Stage 1 RSA - Road Safety Audit Addendum Response Report [Rev P1]

North Littlehampton, Phase 2 comprising Parcel C1 and Part Parcel B2, B4 and C2

Stage 1 RSA – Road Safety Audit Addendum (2) Response Report

Drawing number
A/PHLITTLE-INT.1/11-1

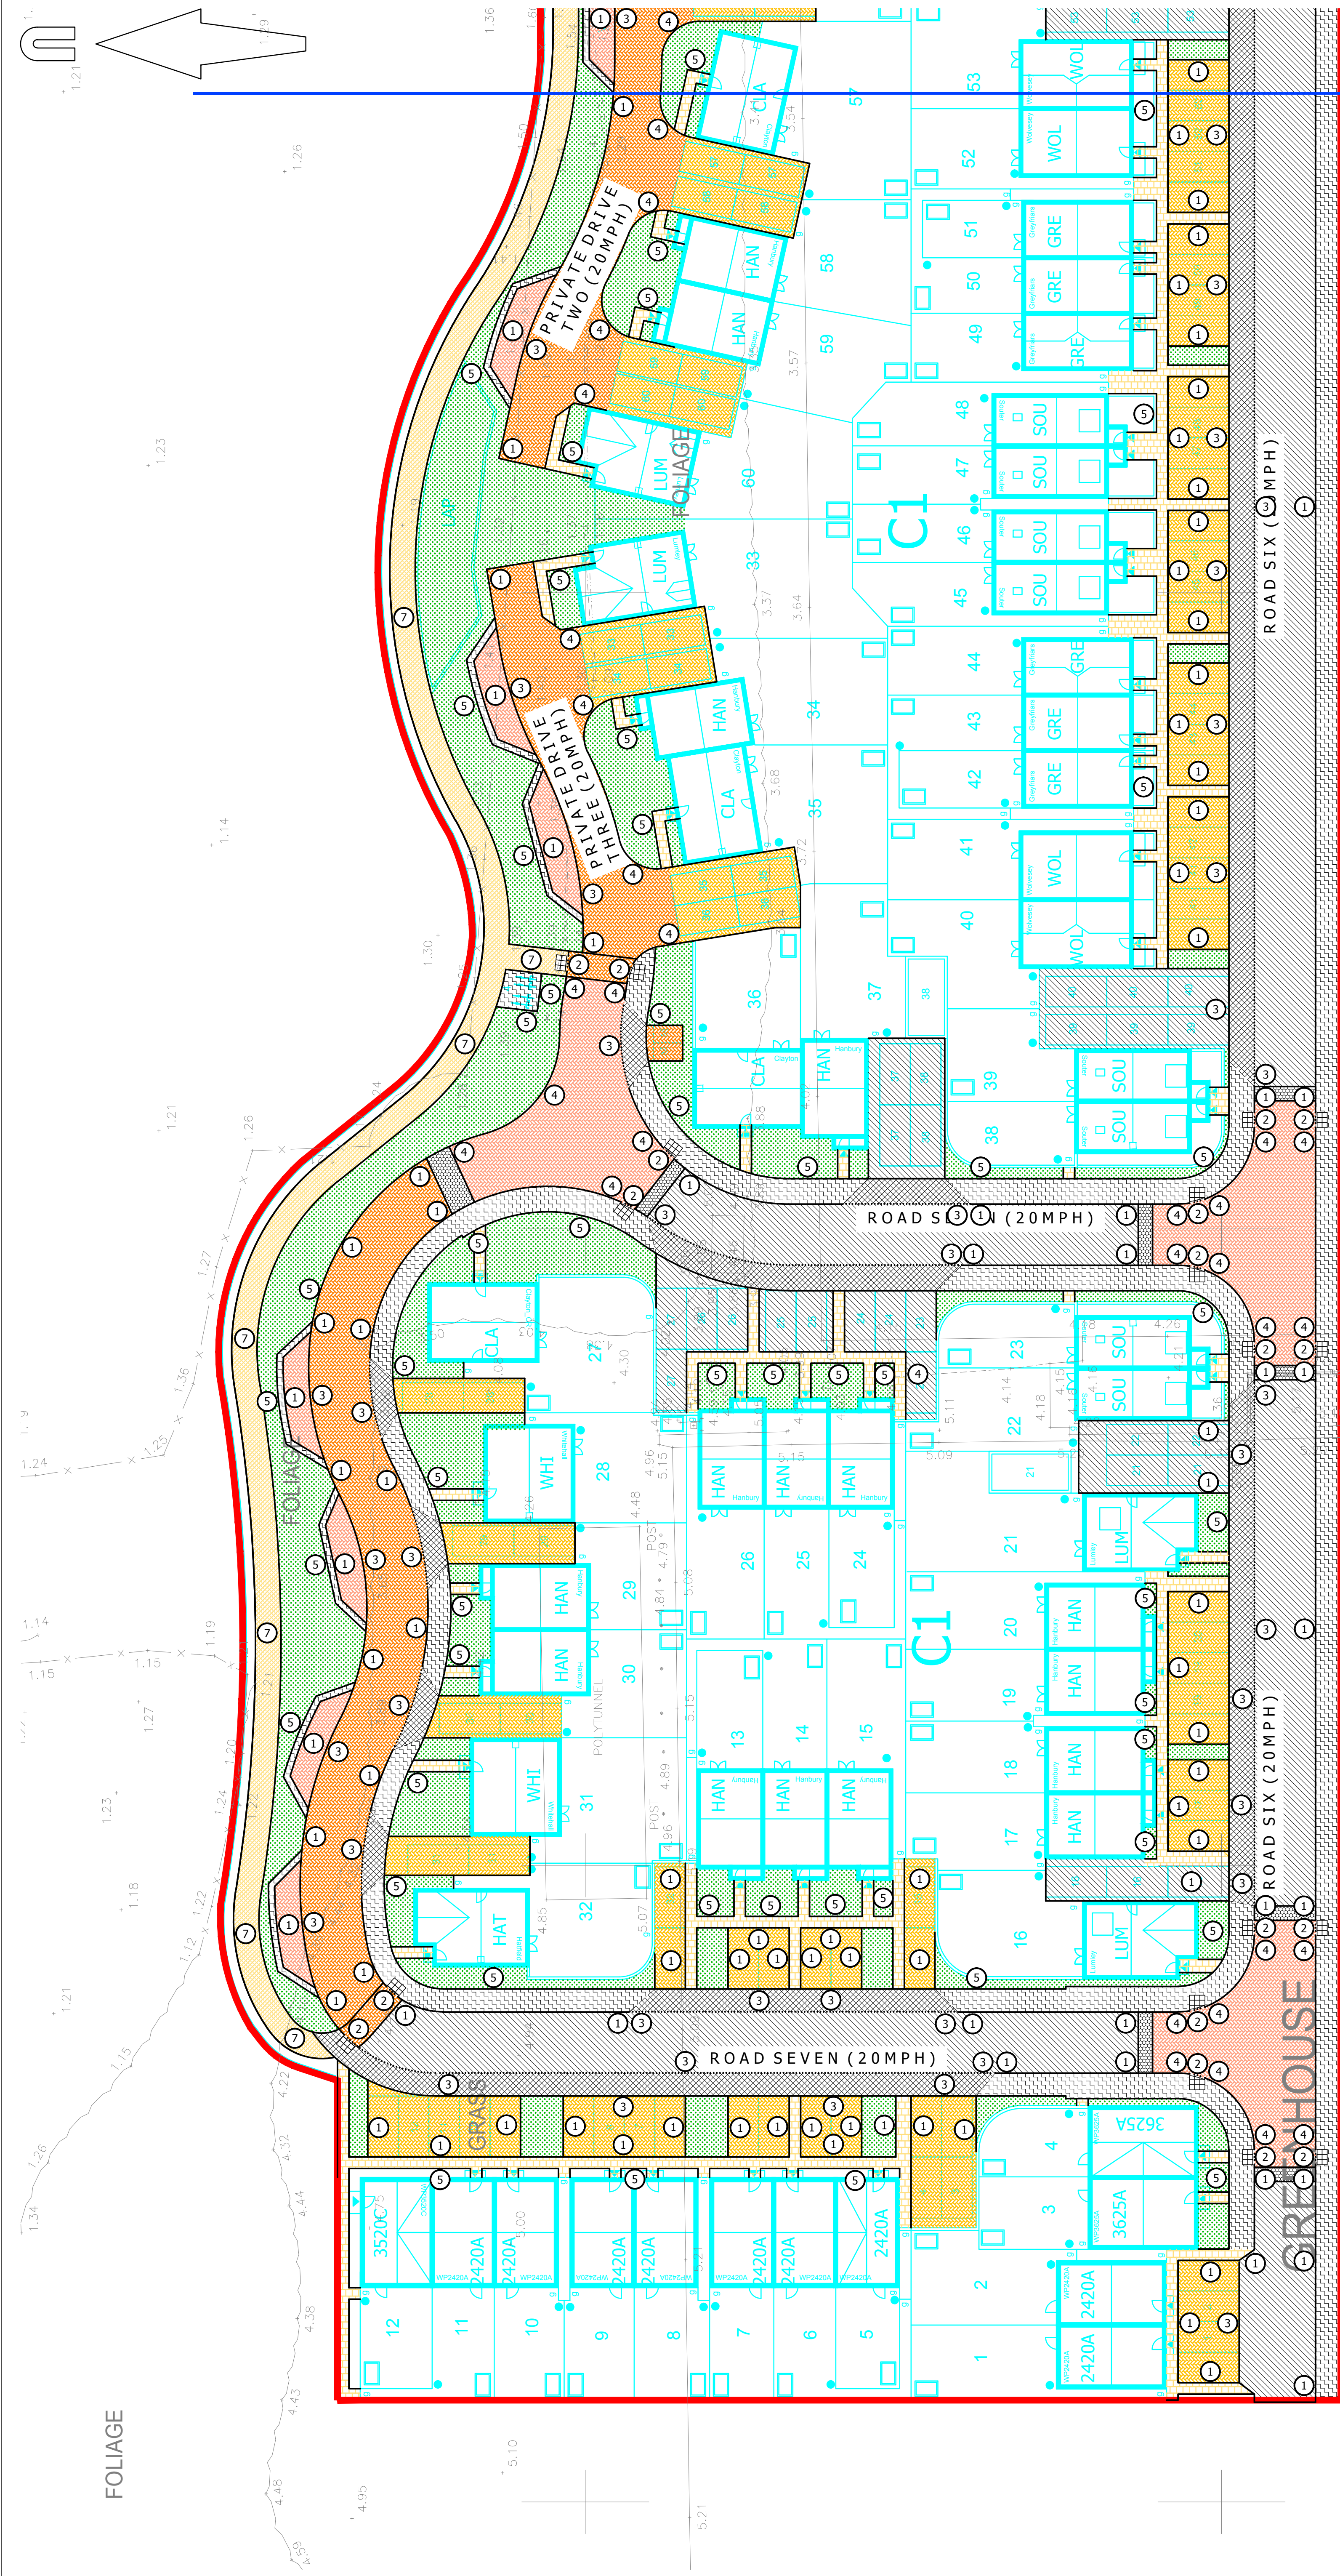
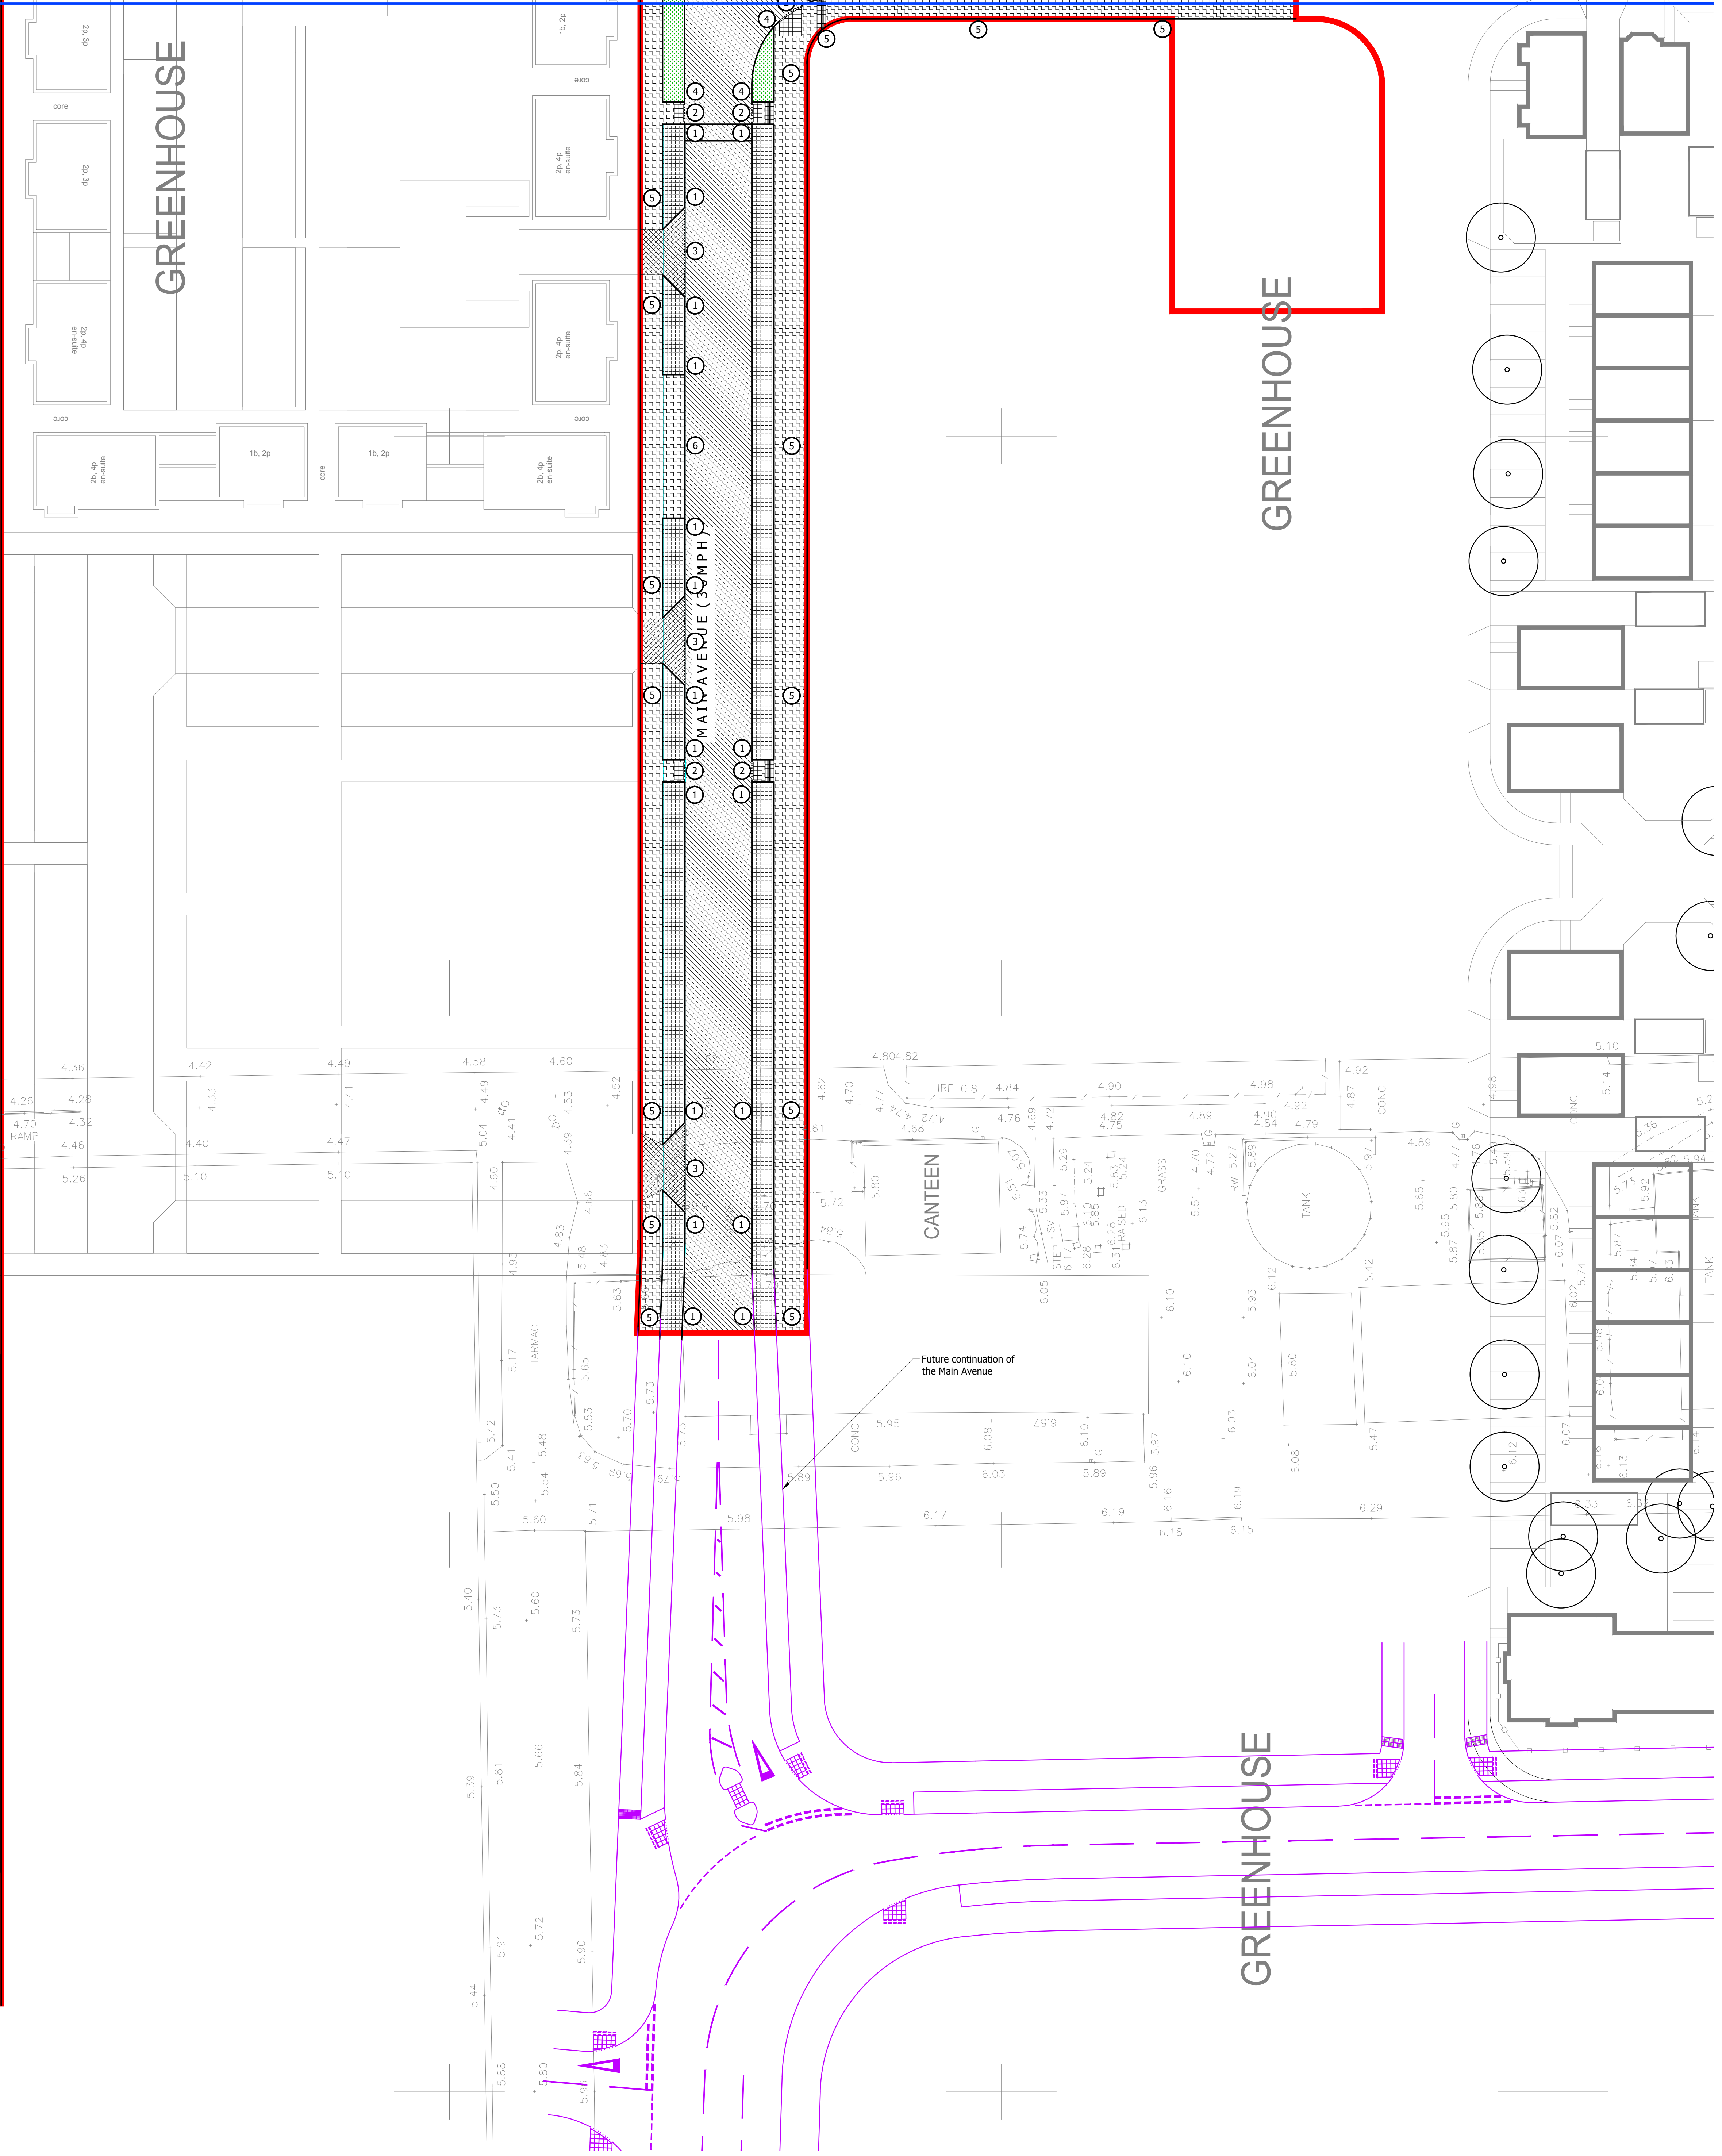
Item	Problem	Recommendation	Designer's Response
3.1	Location: General Summary: Visibility splays Whilst some visibility splays have been formally identified on the drawings submitted, it will be important that all visibility splays remain free from obstruction. It is noted that some visibility splays extend across / through 3rd party land, cycle storage areas or parking bays (on 3rd party land). A number of trees are shown within the verges of the development site, some of which appear to be within the junction visibility splays. Even if the trees are intended to be of relatively small girth and have clear stems, they will inevitably have some impact on sightlines; this effect will be greater the closer they are to the junction and will increase with time as the trees grow. This will increase the risks of vehicles emerging from the side roads being struck by passing traffic.	i. Provide visibility splays in accordance with relevant design standards and ensure that the splays will be kept free from obstruction. ii. Any vegetation within the splays should be maintained to ensure that it does not extend beyond a vertical height of 0.6m. iii. Do not plant trees within the visibility splays.	(i) - Visibility splays have been indicated in accordance with design standards as recommended. On inspection the radii on approach to the pedestrian visibility splays adjacent to the Motorcycle Parking and the Pedal Cycle Parking bays (near dwelling 36) are a maximum of 18m. Thus calculating curve design speed it can be determined that an 18m radius translates to a vehicle speed of just over 23 km/h. Thus in accordance with MfS Table 7.1, this corresponds to a Stopping Site Distance of 17m. Thus the visibility splays have been adjusted to indicate this and now do not encroach on the cycle or motor cycle parking areas. In relation to the car parking associated with Dwelling 31, this has been moved backwards to avoid parked cars obstructed visibility. Furthermore, PHTV has confirmed that the development will be run by a management company and it will be made clear that all visibility splays are to be kept clear of obstructions (other than the street trees). (ii) – PHTV has confirmed that the development shall be run by a management company and any vegetation shall be maintained as required. (iii) – Trees within visibility splays are required along the Main Avenue to create the tree lined street effect and therefore, an Exception to this 'Problem' will be required.

Resulting Amended drawings revised as above:

A/PHLITTLE-INT.1/10-1 Rev P12
A/PHLITTLE-INT.1/11-1 Rev P13
A/PHLITTLE-INT.1/13-1 Rev P7
A/PHLITTLE-INT.1/19-1 Rev P6
A/PHLITTLE-INT.1/TK-1 Rev P9
A/PHLITTLE-INT.1/TK3 Rev P5
